YorkshireWater

**2nd November 2021**

**Your Ref: 2021/1089**

**Land to the South East of Higham Common Road, Barnsley (Application 2) - Hybrid application for employment development comprising:- a) Full planning permission for: earthworks to create development platforms; strategic drainage ponds and associated drainage infrastructure; and location of strategic landscaping and ecological areas. b) Outline planning permission seeking approval over means of access and landscaping for employment use development (use classes E/B2/B8) and associated infrastructure works**

Figure 3 – Illustrative Masterplan

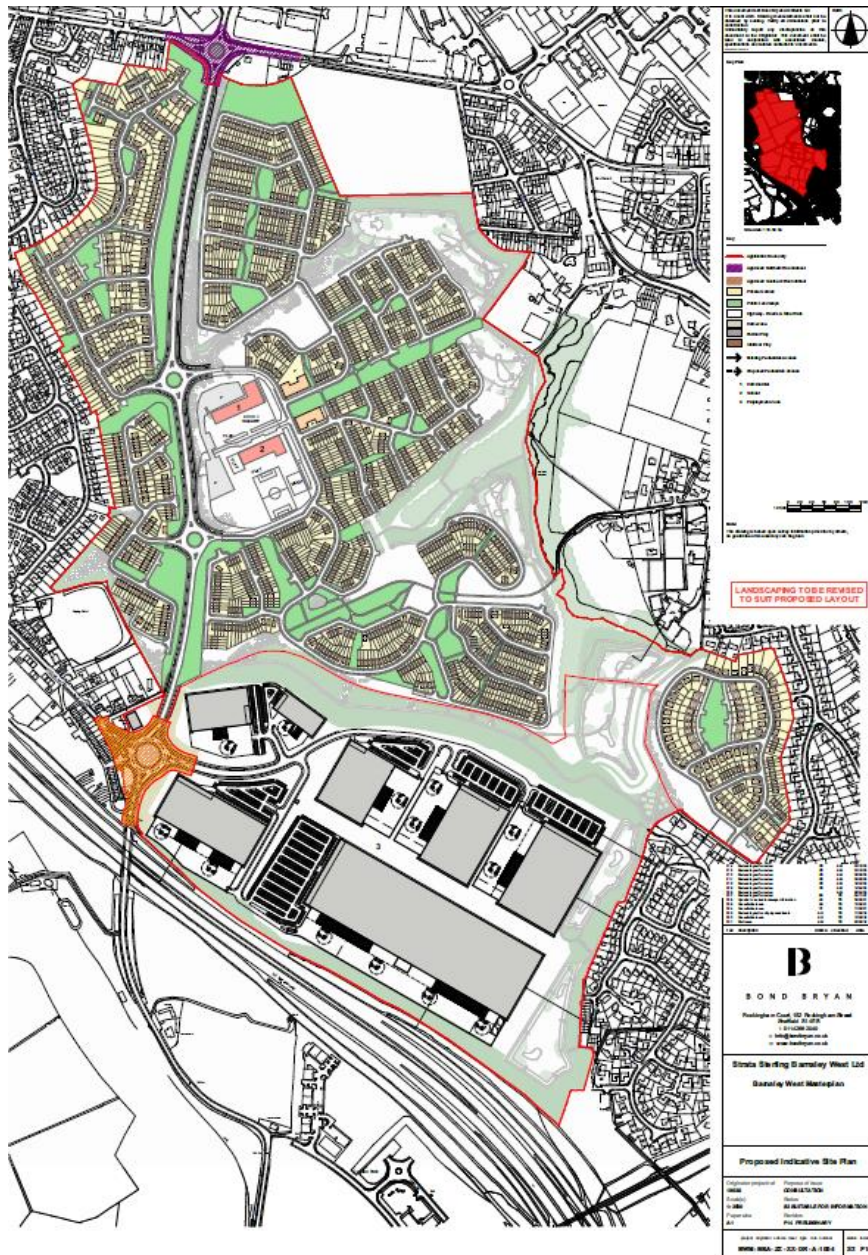
1) Based on the submitted "Illustrative Master Plan 2021189", the site is a large development area with significant development and demand. A large feeder / spine main will be required, with the northern and southern supplies to be linked (from the proposed Northern R/bout to the Southern R/bout).

A suitable hydraulic assessment needs to be undertaken to ensure that the needs of the developed site can be met. Significant off site laying/mains reinforcement may be required.

NOTE: The northern and southern roundabouts will require clean water apparatus to be diverted to facilitate the new traffic islands that are proposed.
